# Chapman Agritainment

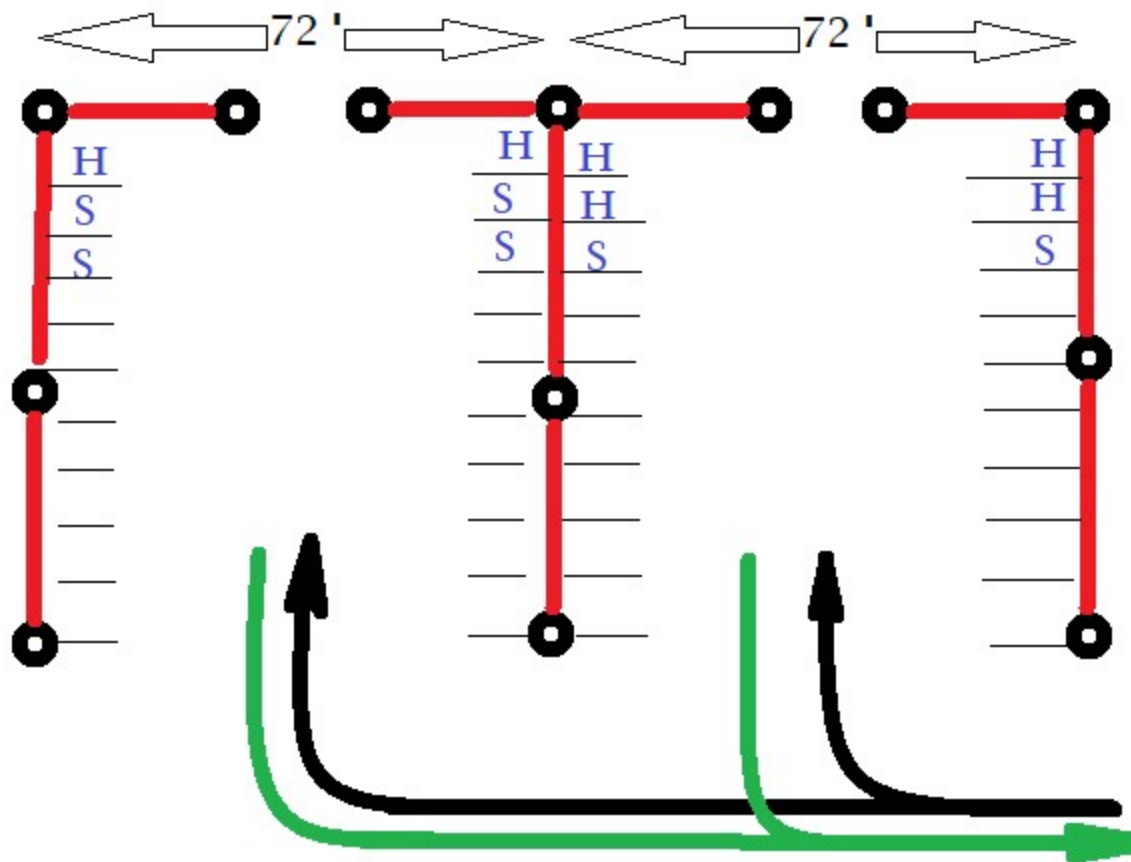
Put a North Arrow on this map.

Please show the floodplain on this site plan as it is shown on the attached document which shows the limits of the 100 year floodplain within your parcel.

Show 25 foot building setback along with the 15 foot landscaping buffer.

Mark that this area is a separate application.

Write "PPR1825" here
